Job Name: **NW Bicester Appeal**

Town and Country Planning Act 1990
Appeal by Firethorn Trust
Land at North West Bicester, Charlotte Avenue, Bicester
Local Planning Authority Ref no: 21/01630/OUT
Planning Inspectorate Ref no: APP/C3105/W/23/3315849

Proof of Evidence of Patrick Moss BSc (Hons) Dip TP MRTPI
on behalf of Cherwell District Council

Network Layout Diagram

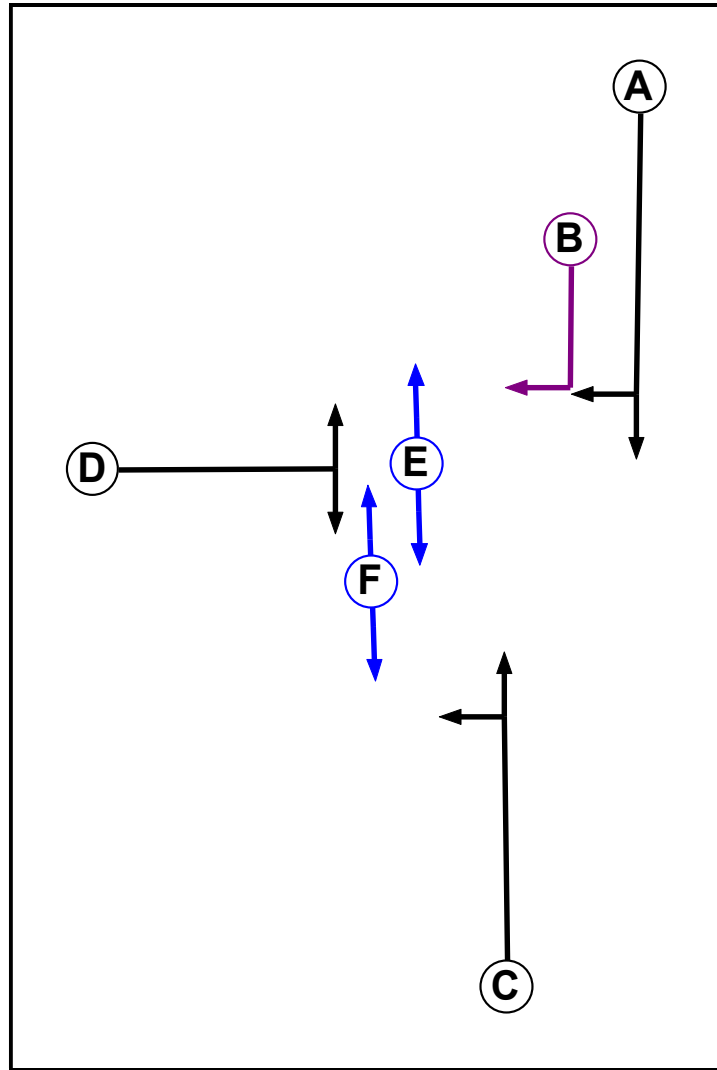
36. On the LinSig model (table 9.3 of the TA) all arms are signalised and thus the capacity is shared more evenly across the junction rather than the B4100 having absolute priority. In this model the measure is DOS (degrees of saturation) rather than RFC - Charlotte Avenue has a DOS of 82.5 (100 would be complete saturation) and the B4100 (north) has a DOS of 86.9. Normally a DOS of 90 is regarded as the cut-off point beyond which the arm might be regarded as over-capacity. Delays are not quoted in table 9.3 but queues are, the queue on mean maximum queue on Charlotte Avenue in the AM peak is stated as being 7.9 vehicles. One would expect a queue this length to clear in one phase of the signals. There are also queues recorded on the B4100.

39. The traffic signals are based on a possible layout shown on drawing 4600-1100-T-016 in appendix 2 of the Stage 1 Road Safety Audit, which is itself in Appendix B of the TA. This shows the junction modified with the stop line for the signals set some 15m back from the junction as the bell mouth width makes a stop line at the bell mouth unsuitable for signals and the signals themselves make the original location unnecessary as visibility is no longer an issue. The forecast mean maximum queue is 7.9 vehicles which would extend 42m back from the stop line. The combination of the

set back of the stop line and the queue length would extend past the entrance to a small car park that currently serves the marketing suite but that will eventually serve the residential units that replace this. A vehicle turning into Charlotte Avenue may find itself unable to turn into this car park and would then block traffic behind it until the signals change and released the queue.

40. In considering the above it is necessary to consider also the optimistic modal split that has been assumed. The LinSig model is approaching the threshold of a DOS of 90%, whilst the PICADY model is over the threshold of 0.85. At this level, especially for the PICADY model, small increases can have a dramatic effect on queue length and delay. Thus, if the traffic generation figures used are underestimated the queue length and delay could increase significantly.
